Ref: GOOS3000

MINOR-MATERIAL AMENDMENT APPLICATION (SECTION 73)
UNIT 3A, EAST HORNDON BUSINESS PARK, TILBURY ROAD, WEST HORNDON

On behalf of our client, Goodman, we are pleased to submit an application for a Minor-Material Amendment (Section 73) in relation to full planning permission ref. 22/01751/FUL which approved the construction of a Class B2 / B8 building at the site Land South of East Horndon Hall, Tilbury Road, West Horndon, Essex, CM13 3LR.

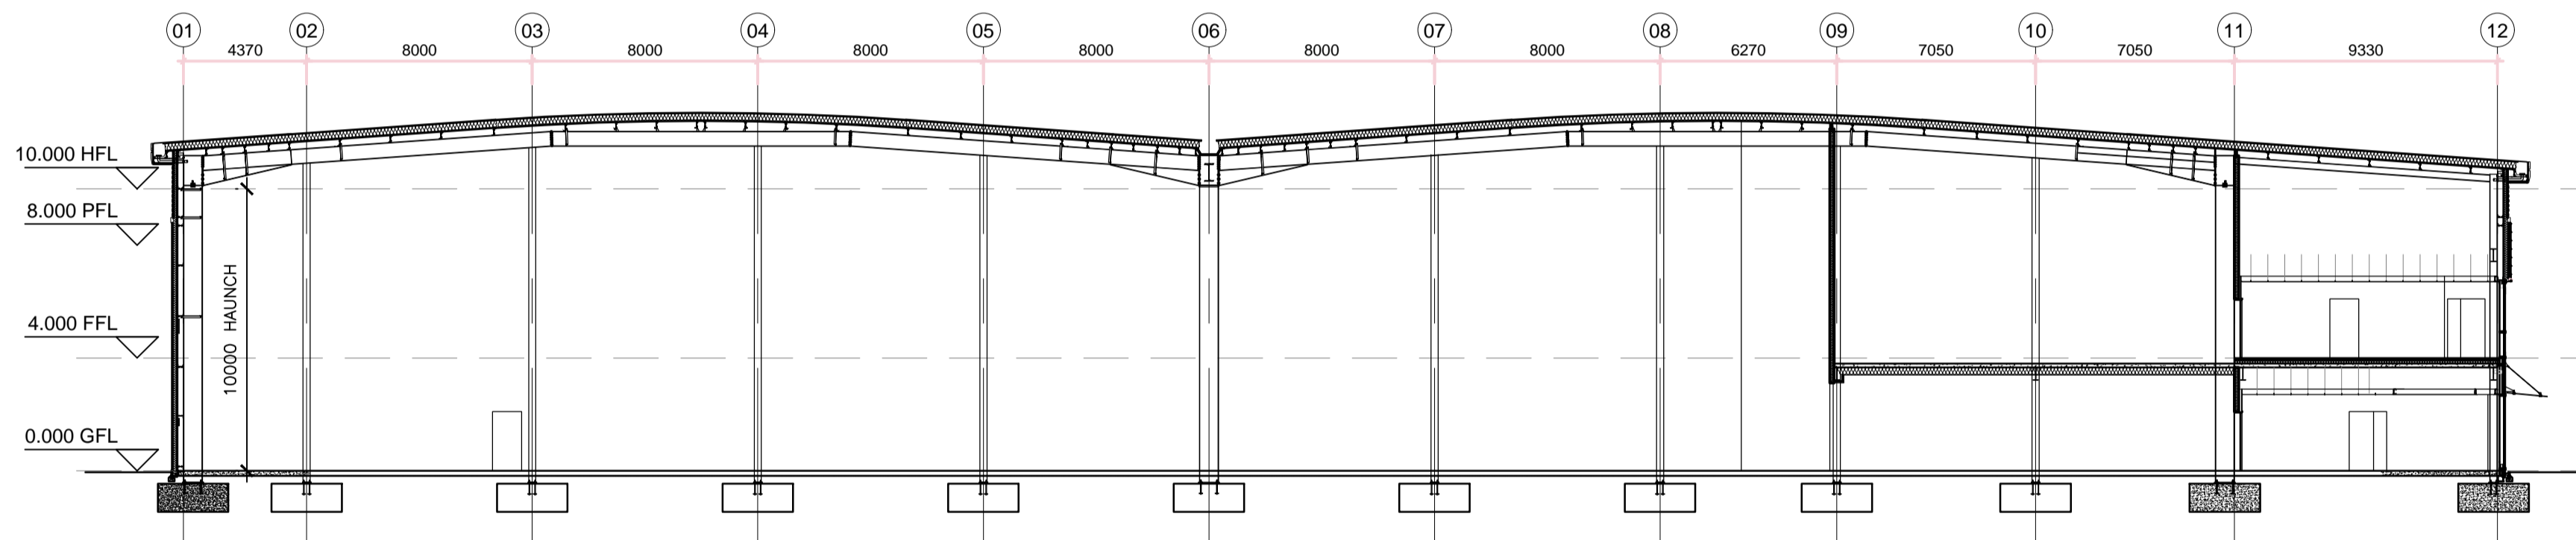
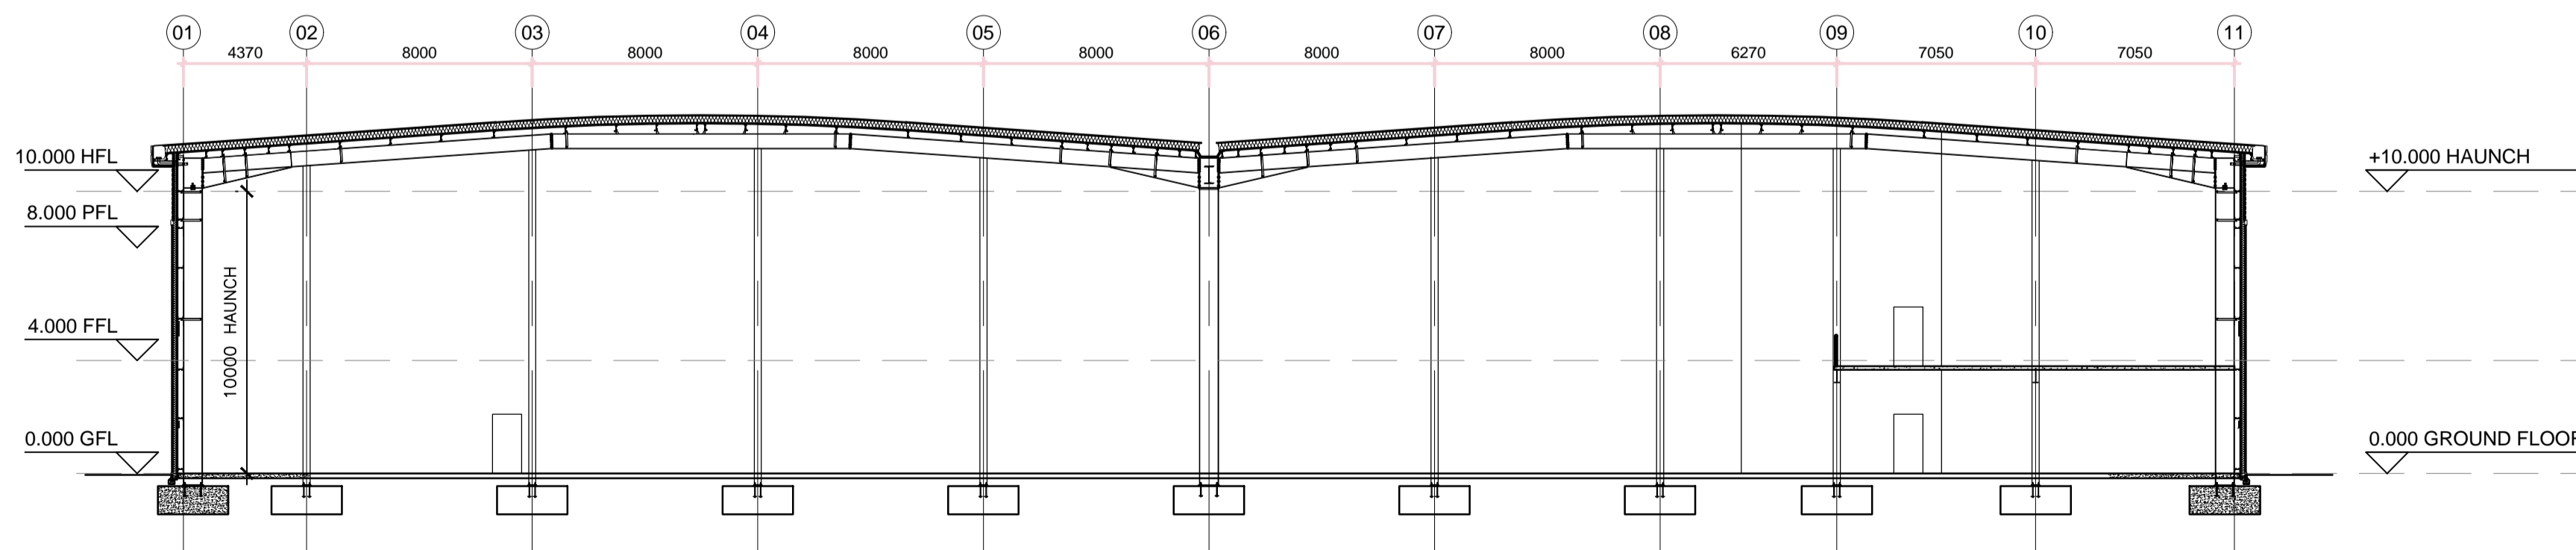
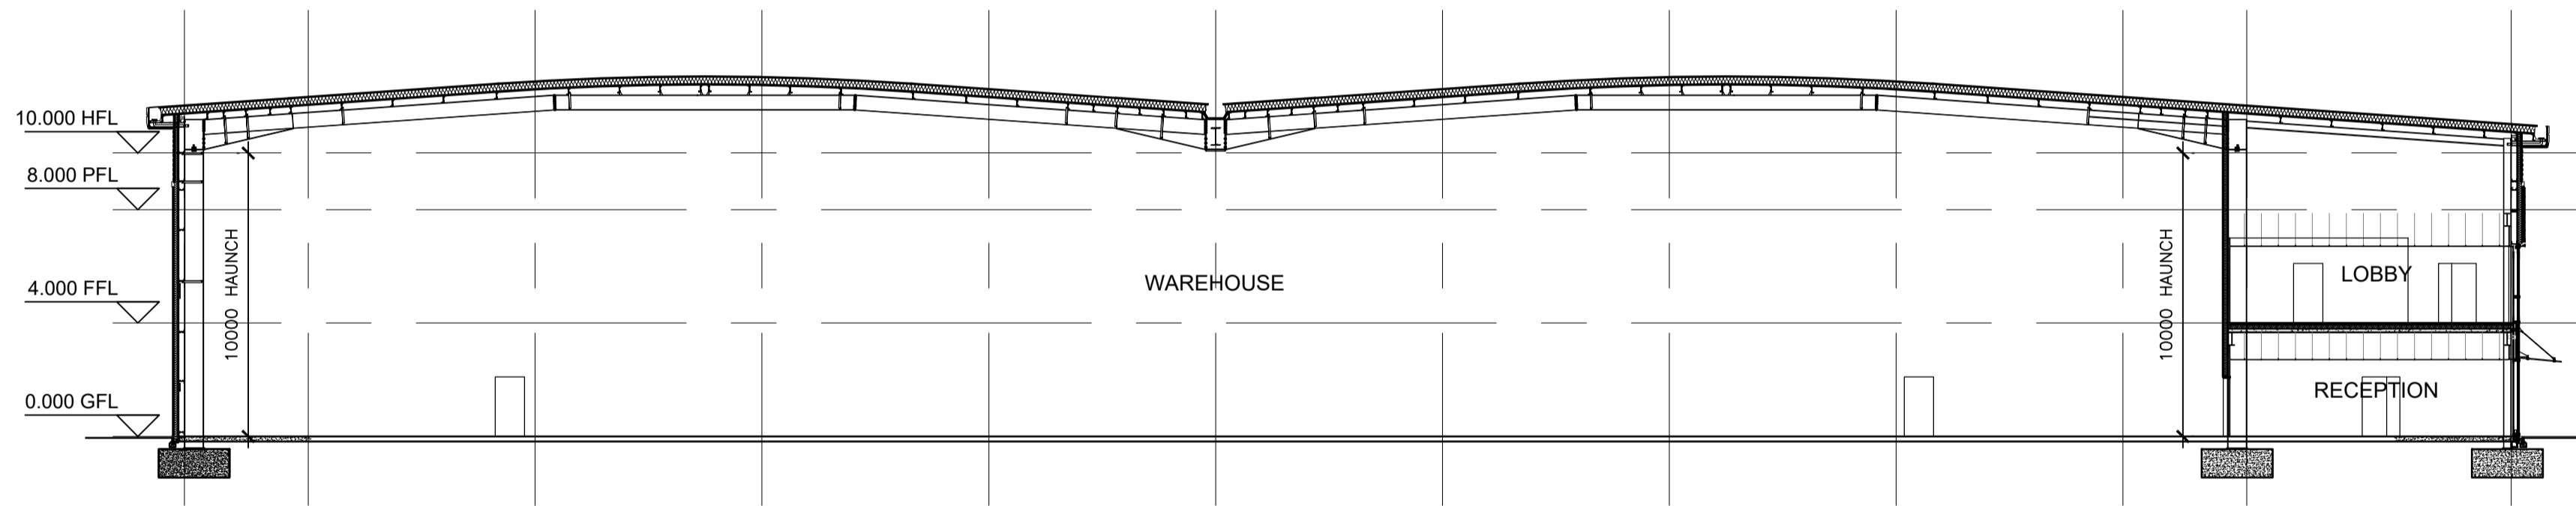
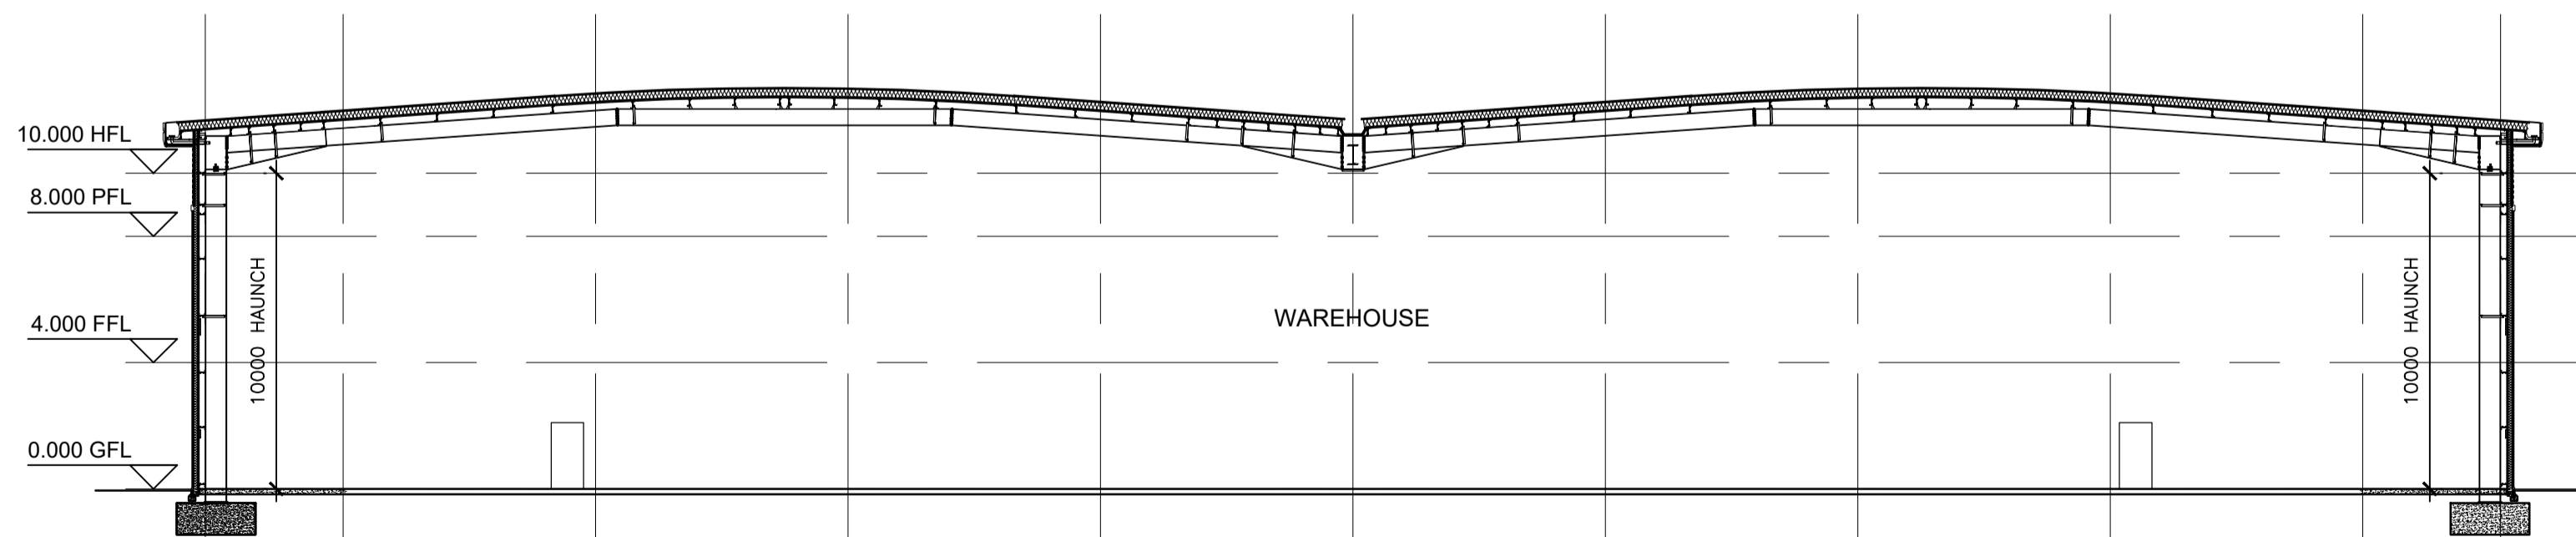
The new occupier requires an enlarged mezzanine area in order to provide additional flexibility for future operations within the building. The mezzanine also takes into account minor changes to the internal configuration of the ground floor including the formation of an ancillary customer area. This change is internal only and does not affect the external appearance of the building.
